**KIRKLEES METROPOLITAN COUNCIL
INVESTMENT & REGENERATION SERVICE**

**DELEGATED DECISION TO DETERMINE APPLICATIONS FOR
CONSENT, AGREEMENT OR APPROVAL REQUIRED BY CONDITION**

Reference No:	2022/44/92236/E
Site Address:	Field House, 15 Wellington Street, Dewsbury, WF13 1BQ
Description:	Discharge of conditions 3 (detailed drawings), 4 (additional storey), 5 (materials), 6 (residential waste), 7 (A3 use waste), 9 (swift nesting), 14 (ventilation), 15 (noise assessment) and 19 (air quality) of previous permission 2019/92962 for erection of additional storey and conversion of building to provide 23 self-contained apartments and A3 use in basement and part of ground floor (Listed Building within a Conservation Area)
Recommending Officer:	Victor Grayson

DECISION – Discharge of Conditions- Split Decision

DRAWING NUMBER:	Status:	Rev:
1441354-HLEA-XX-RF-DR-M-100107	S3	P01

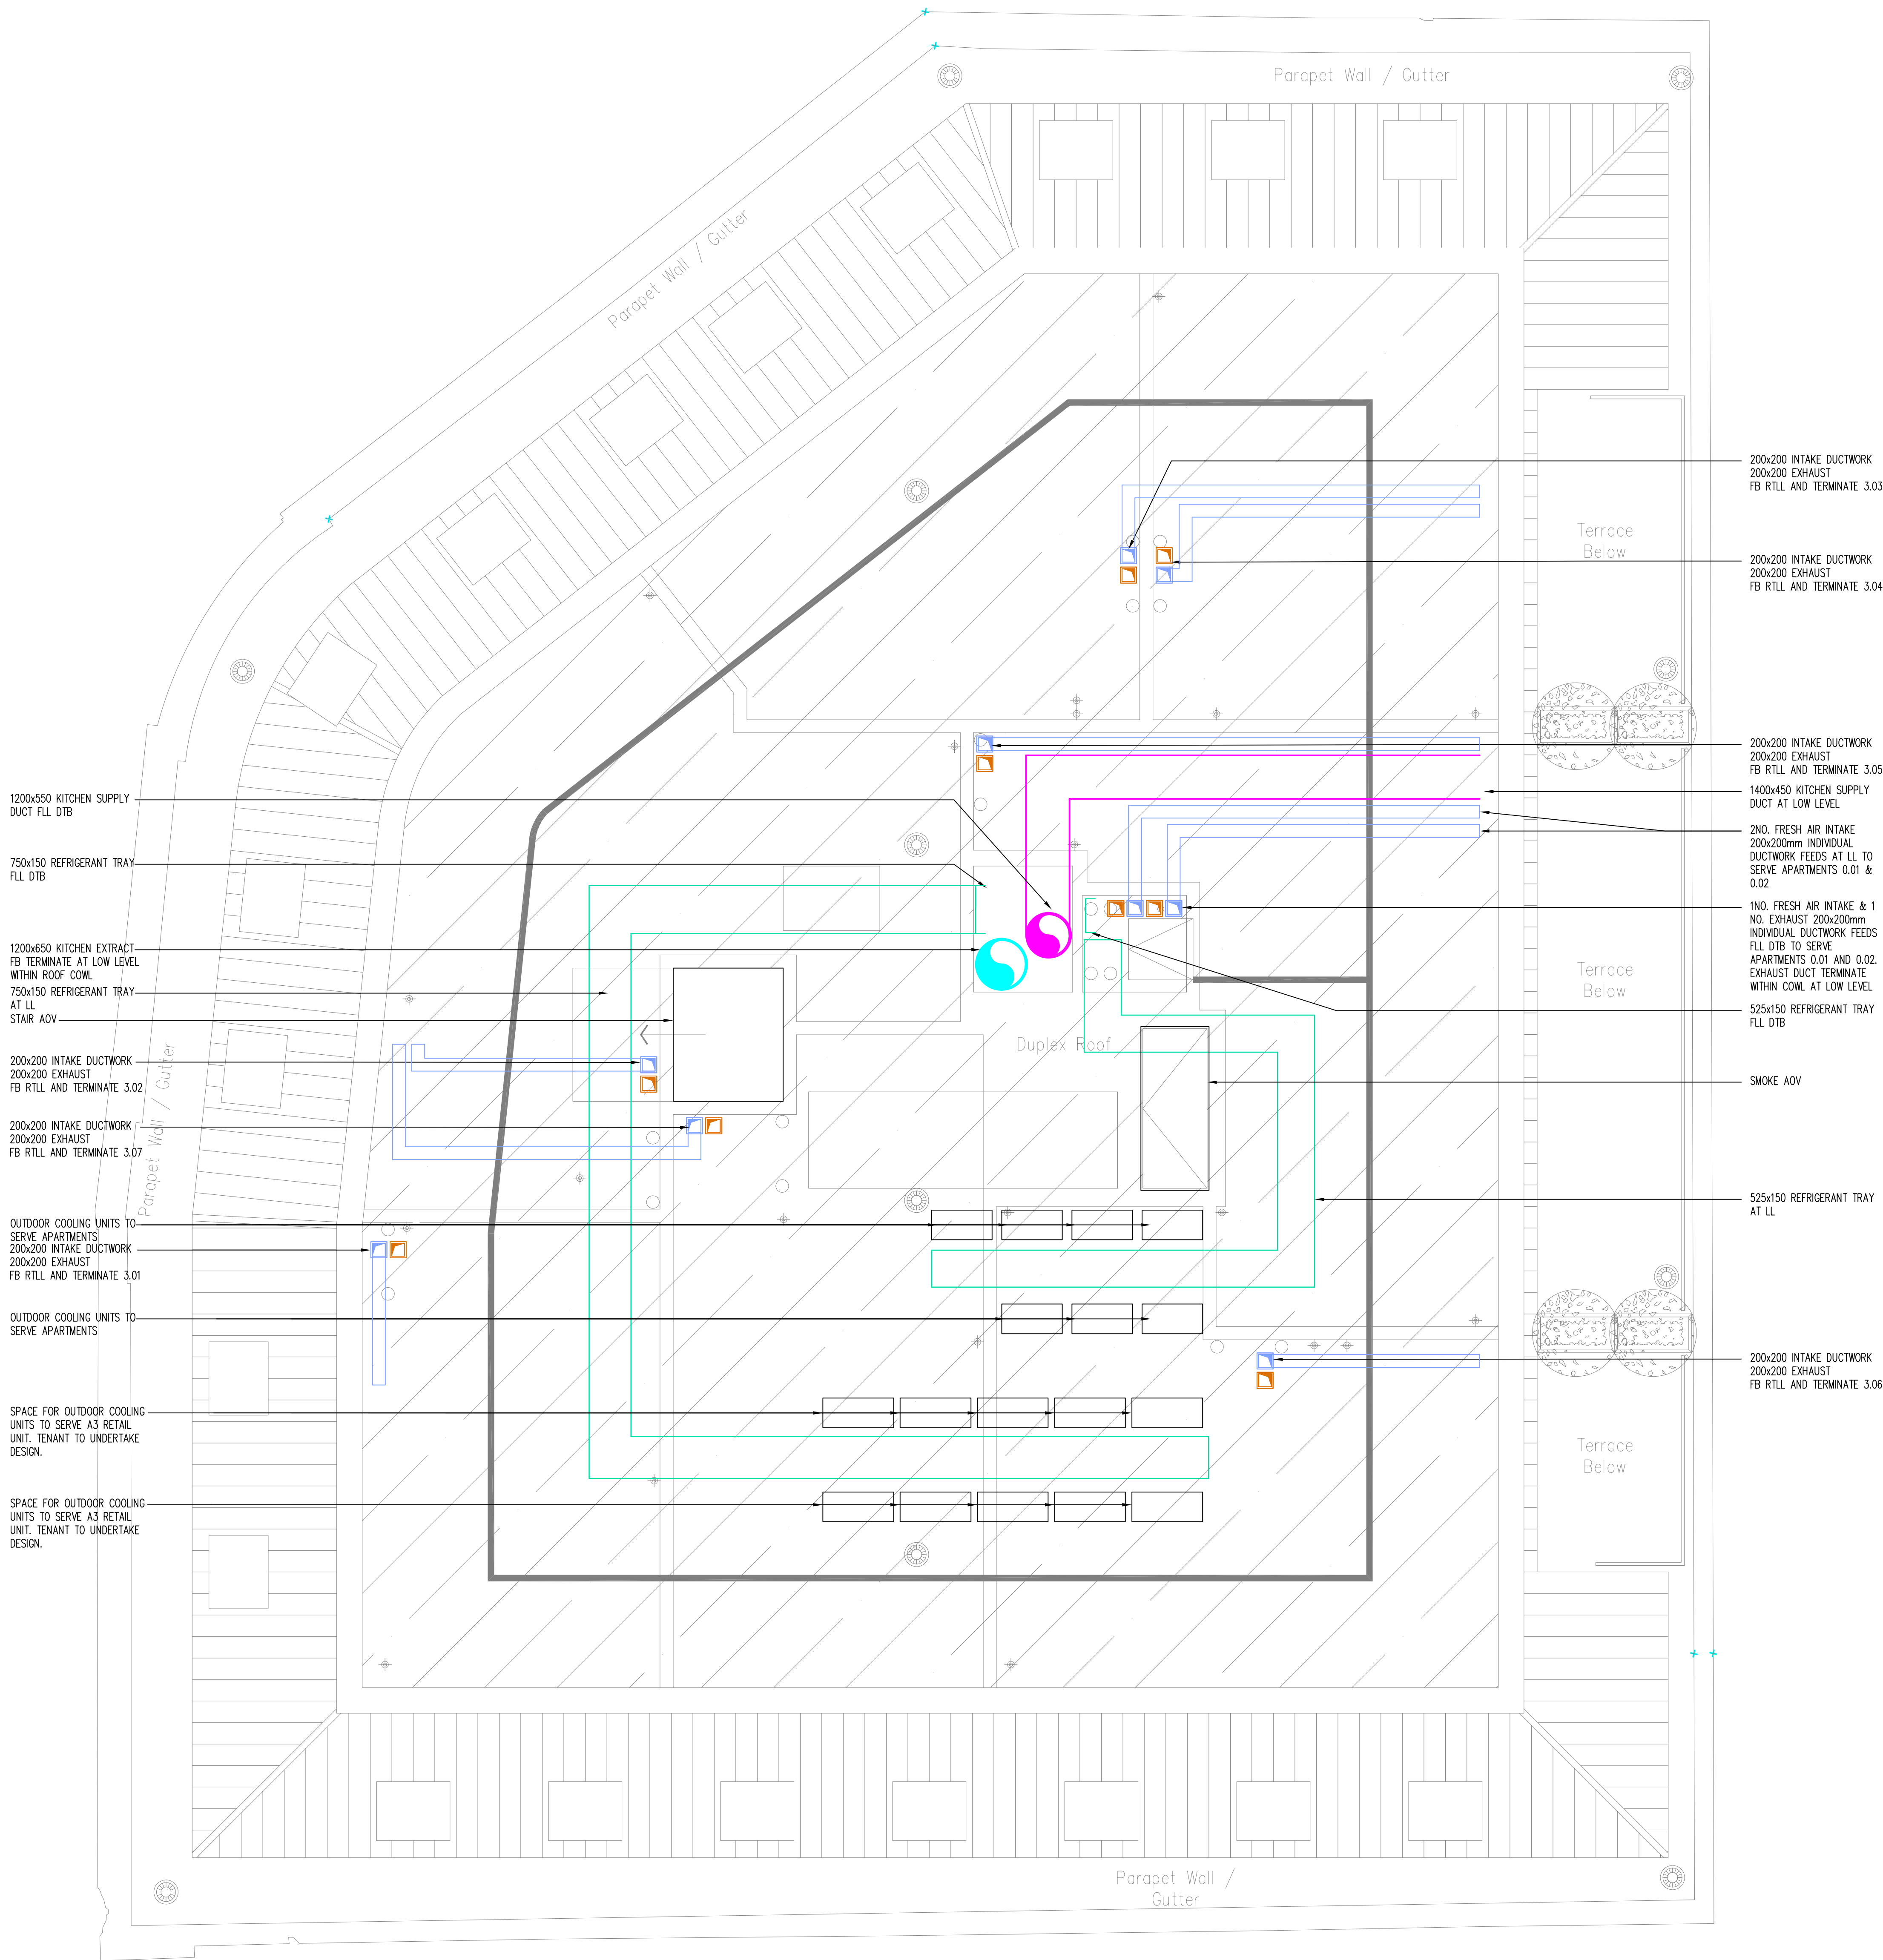
Regarding overheating, the submitted assessment asserts that all habitable areas of the apartments would comply with the TM59 requirements (Criterion 2, Mechanical Ventilation), except for one living room (02-APT 2.01- Kitchen/Living). In order to mitigate the overheating risk in this one room, the applicant's assessment states that consideration should be given to include blinds / curtains or to allow MVHR to operate in boost mode for short periods of time. The six open plan living/kitchen rooms/bedrooms on the 3rd/4th floor where active cooling would be provided would by default comply with TM59 overheating requirements.

Given the above advice, it is recommended that the information submitted pursuant to condition 14 be approved, on the proviso that ventilation measures would be provided for all apartments (to address a further point raised by KC Environmental Health).

01 Site Refuse Strategy Plan
Scale: 1:100

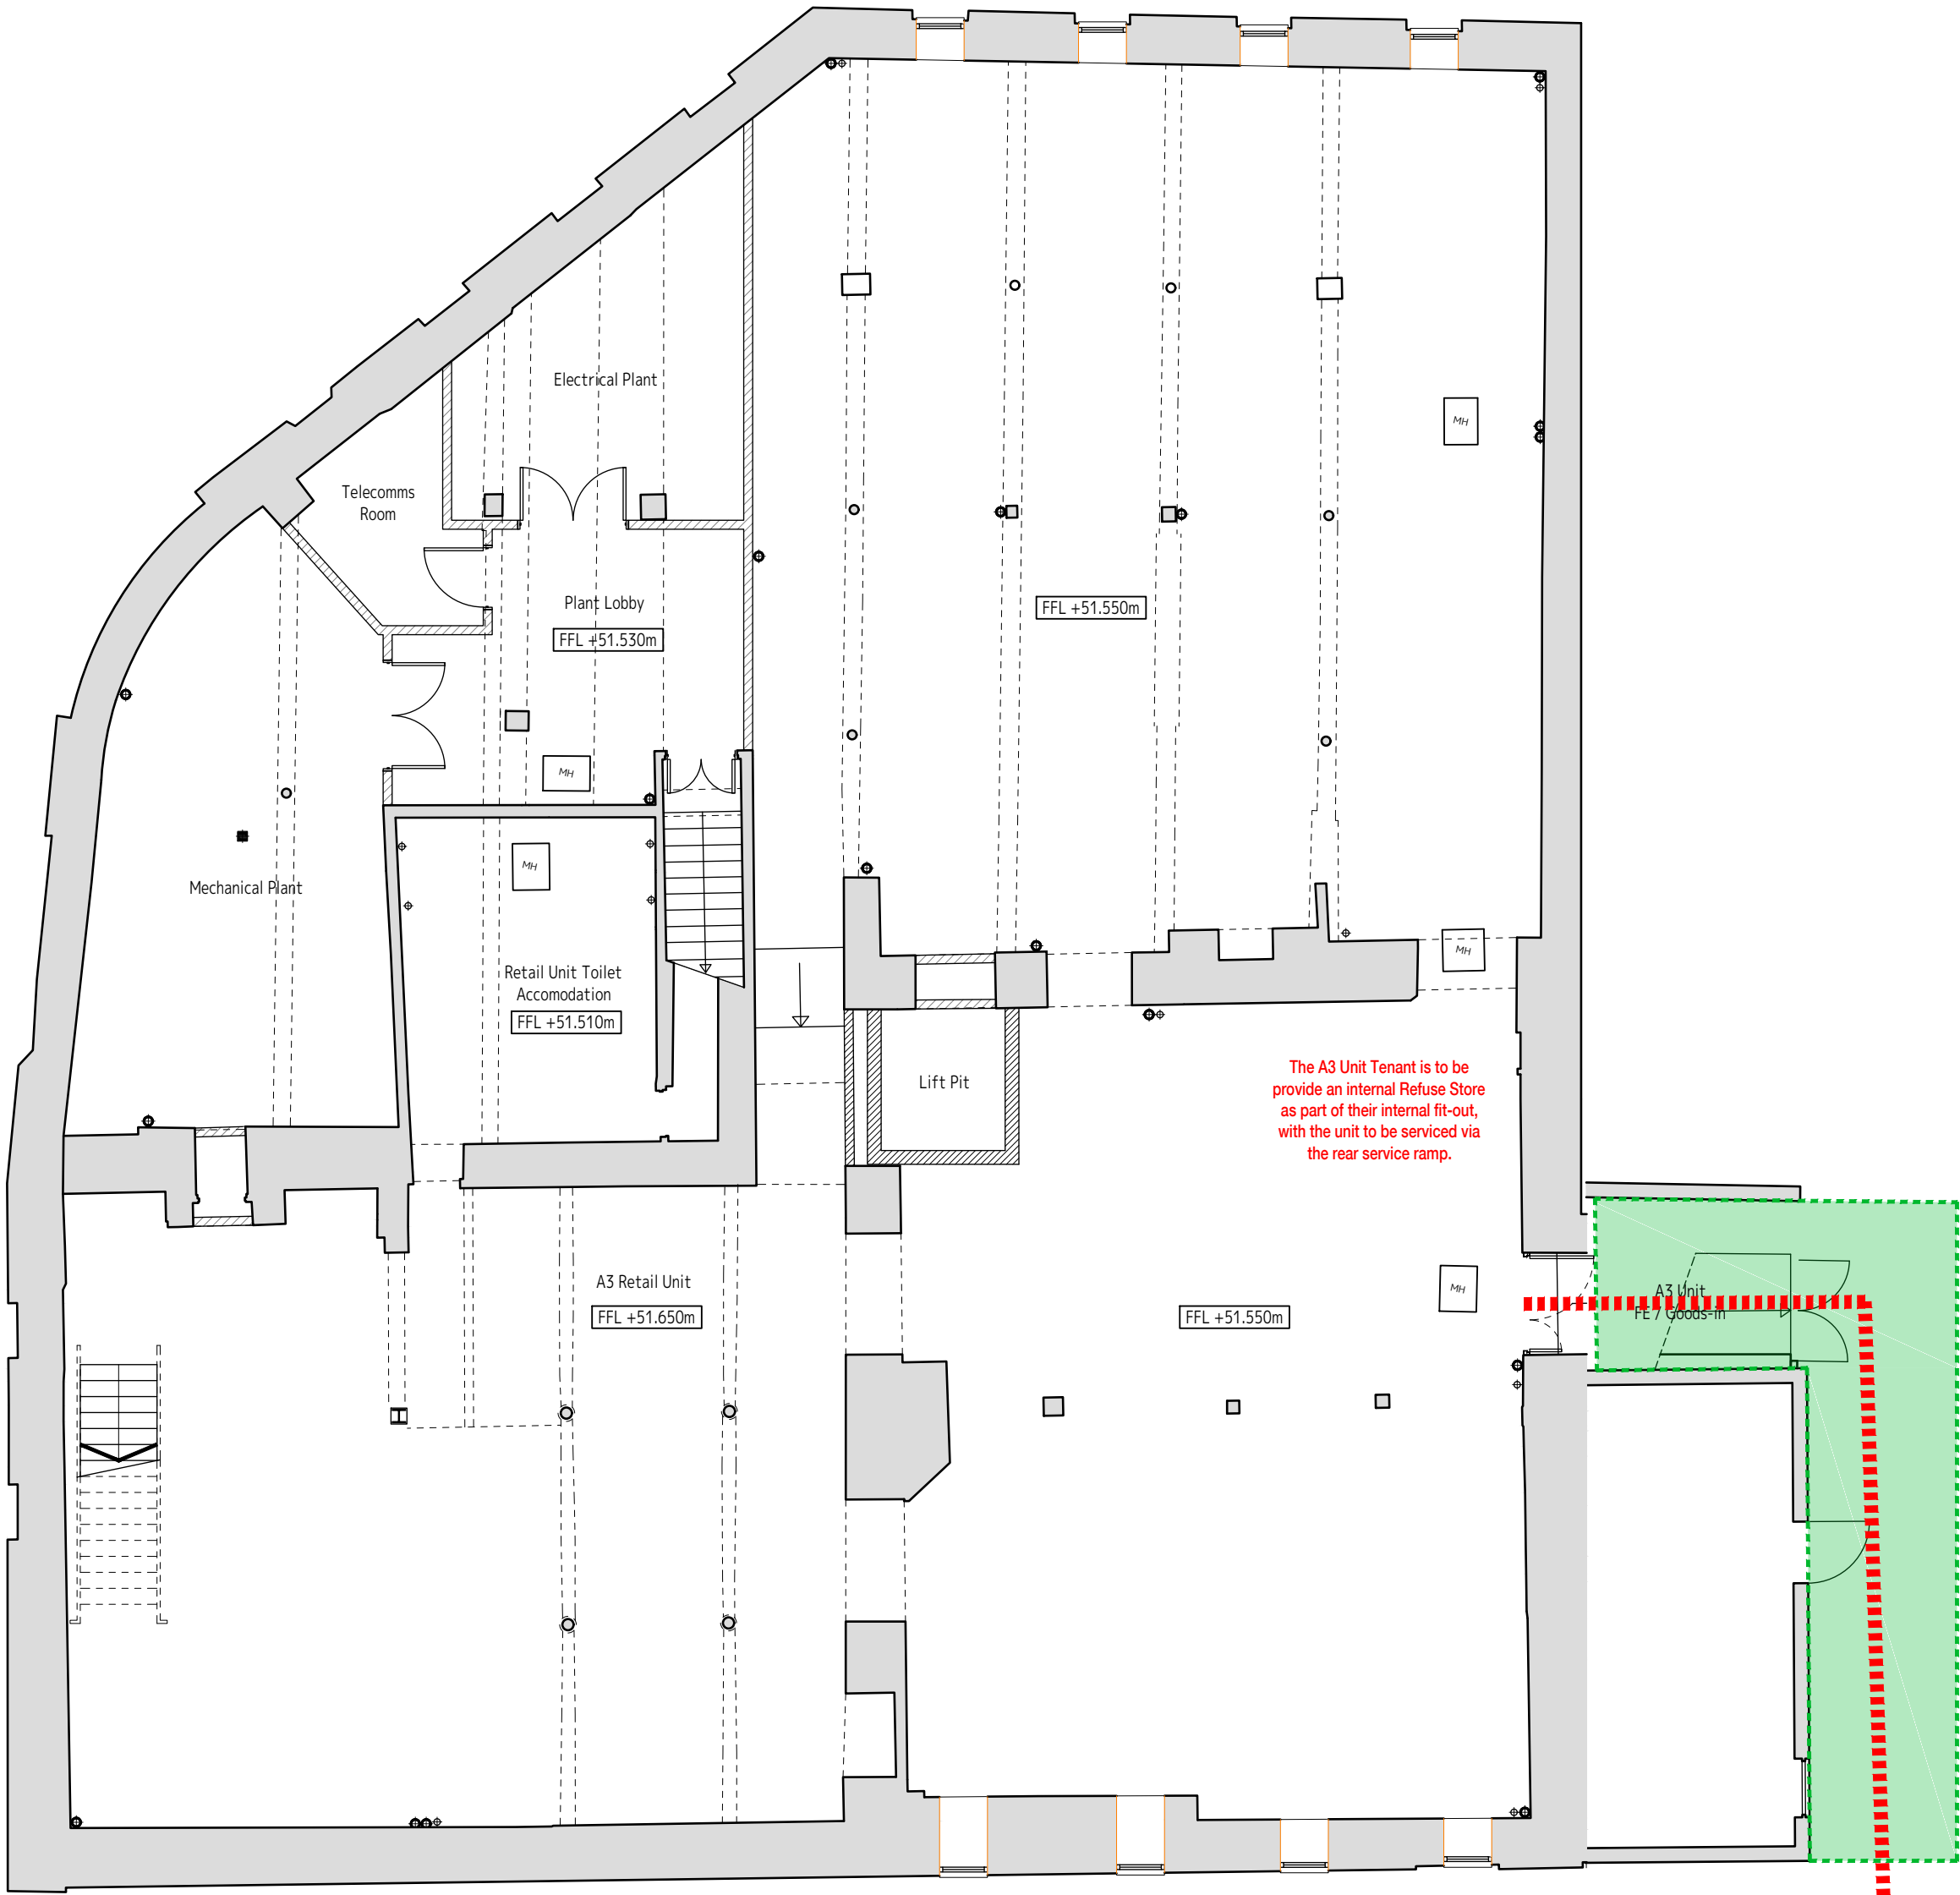
As with condition 6, KC Waste Strategy made initial informal comments, officers met with the applicant team, and an amended drawing (2018-051 0811 rev A titled "Refuse Strategy (A3 unit)") was submitted.

Given KC Waste Strategy's further informal comments of 16/11/2022, it is recommended that the information submitted pursuant to condition 7 be approved.
